Subject: FW: WA/21/21/DOC - Wandleys Farm Condition 3 Materials

1. **Eaves Detail** – please find attached drawing 944 BR07A which includes the eaves detail for the new affordable housing (bungalows). The same eaves detail will be used for the house.

Subject: WA/21/21/DOC - Wandleys Farm Condition 3 Materials

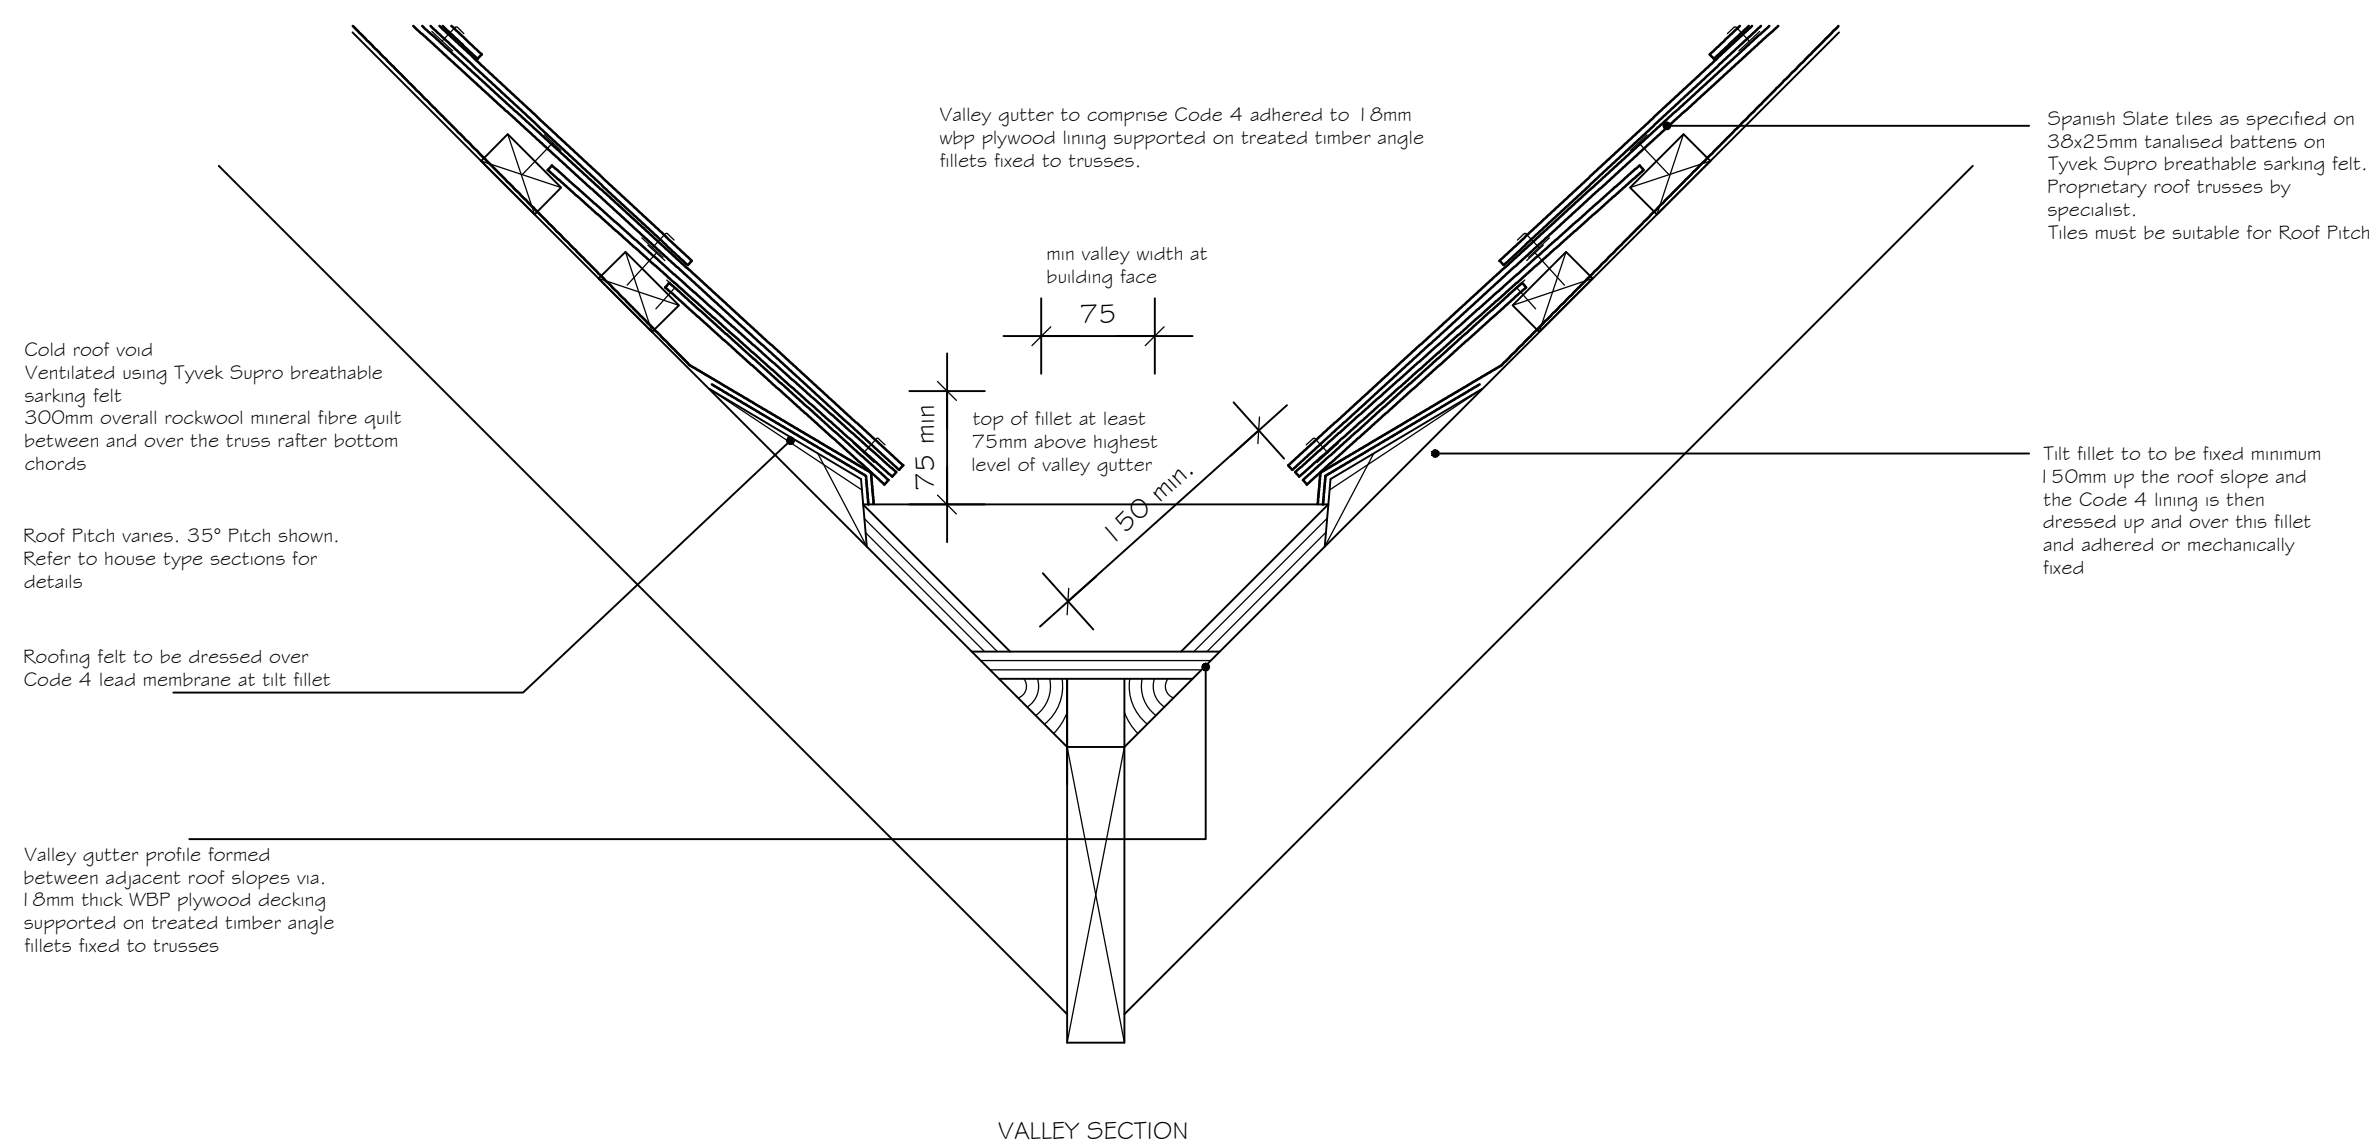
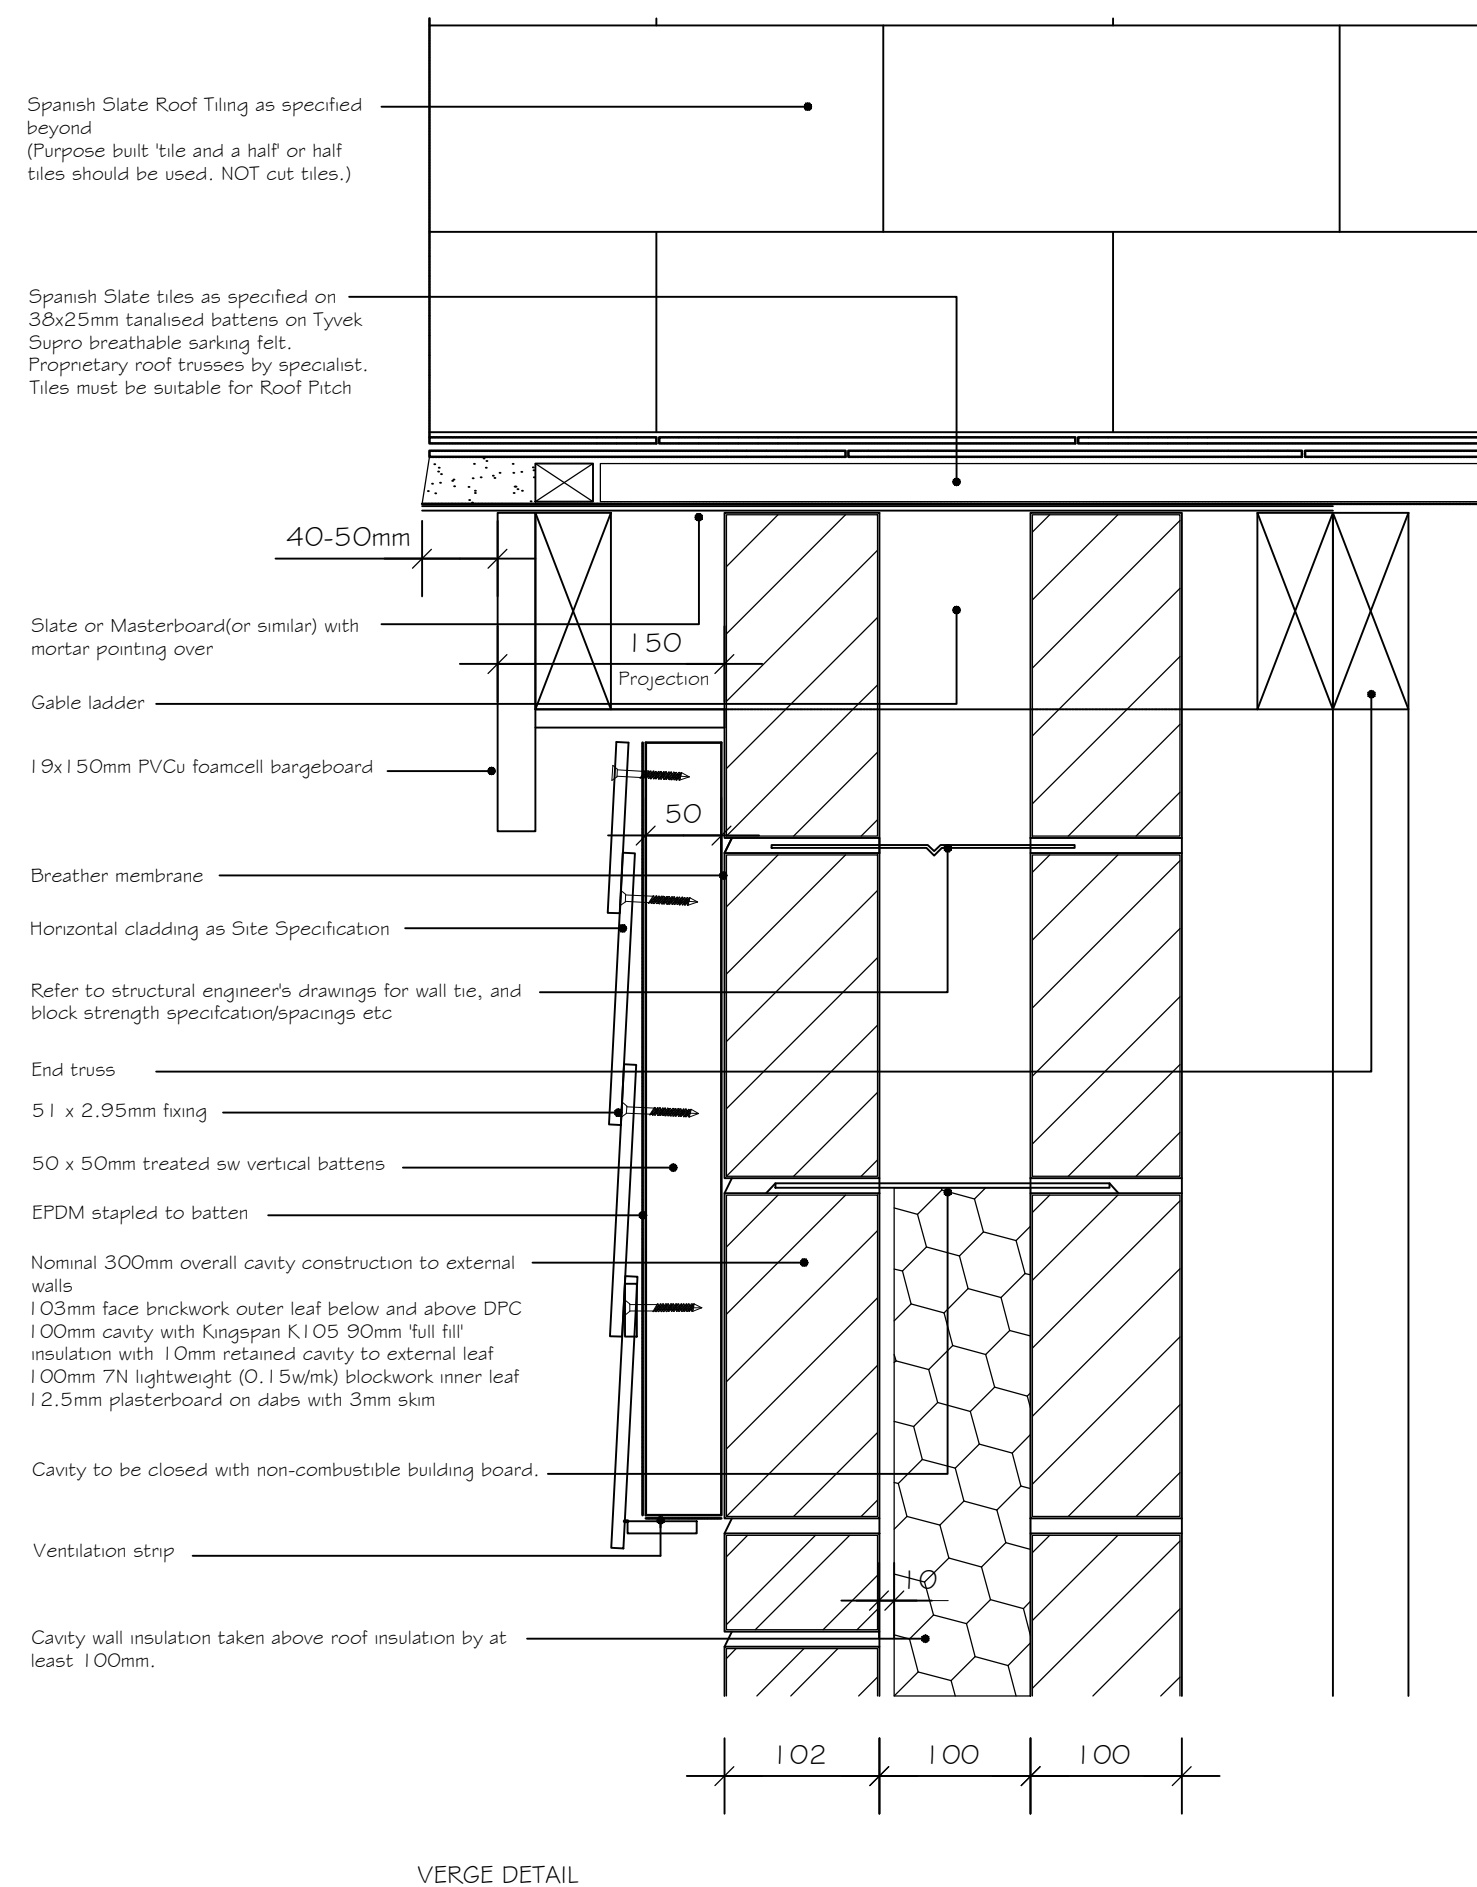
The above application does not contain any eaves detail as required by the condition. If these are not provided within the next 7 days the application will be determined as submitted.
